From: Contact Centre (CRM) <contact@ribblevalley.gov.uk>
Sent: 29 September 2022 21:41
To: Planning
Subject: Planning Application Comments - 3/2022/0722 FS-Case-455318806

Planning Application Reference No.: 3/2022/0722

Address of Development: Mayfair Slaidburn Road BB7 3JJ

PROPOSED PART SITE PLAN  
Scale 1:100

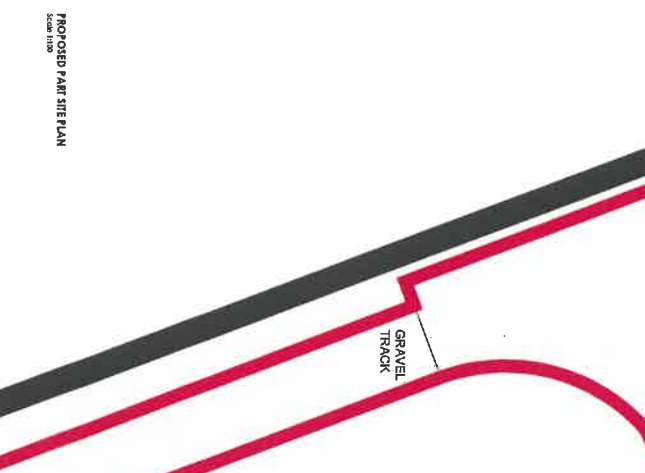
The proposed plans also allow for two parking spaces to be created alongside the site, clearly building a car park in a field (not matter how small) is not in keeping with its existing use and more importantly would be entirely out of keeping and character for the area which is currently open countryside. Equally it suggests that there will be the appearance of having a working facility in the shed (whether that is the intention or not) which would mean that if granted it would be more difficult for the Council to object in the future to other suggestions in other fields.

PROPOSED SITE PLAN
Scale 1:500
1:500 Scale

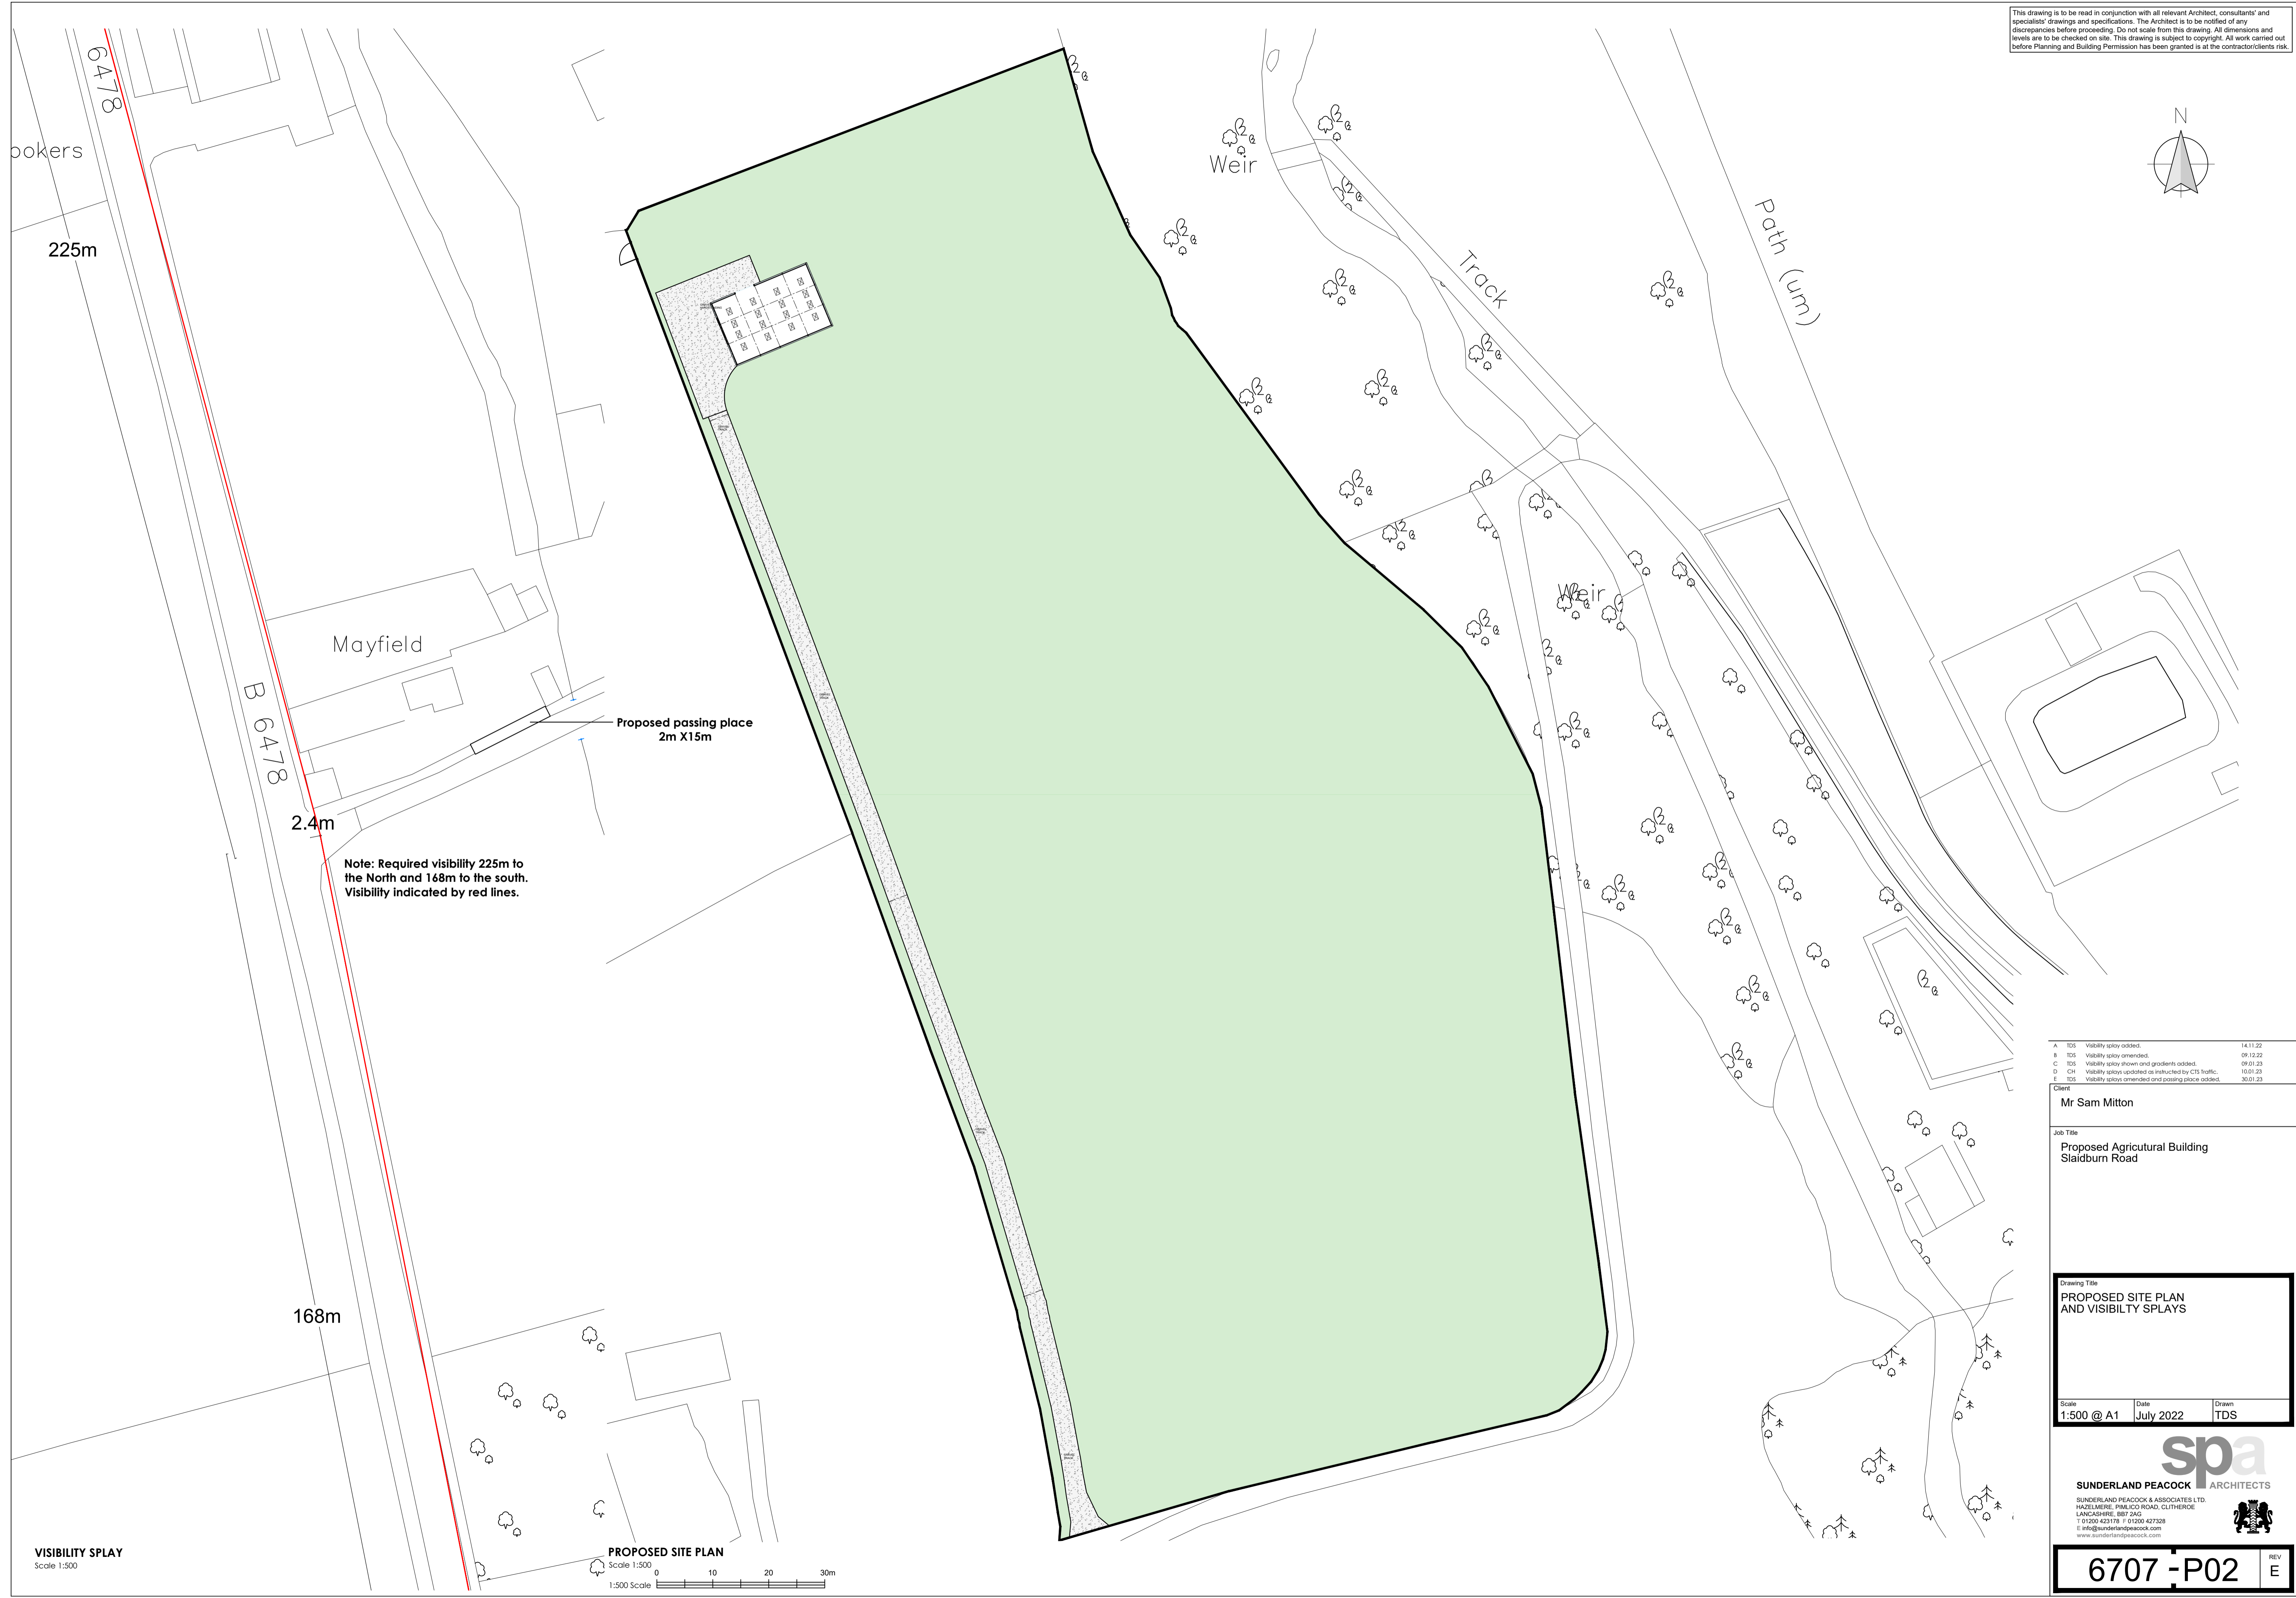
The proposed location involves running a new access road up the entire length of the [REDACTED] entirely changing the rural nature of the area. The proposed site is currently a hay meadow next to a hay meadow visible from across the valley. If this development is approved it would become a hay meadow next to a purpose built shed with an access road that would also be visible.

There is no economic sense in locating the yard in the location applied for there is space at the bottom of the field next to the existing road which would avoid the need to build any access road? A business would focus on keeping cost to a minimum as opposed to building a road to a currently inaccessible part of the field without explanation, especially where the topography would require more work to develop this part of the site than others.
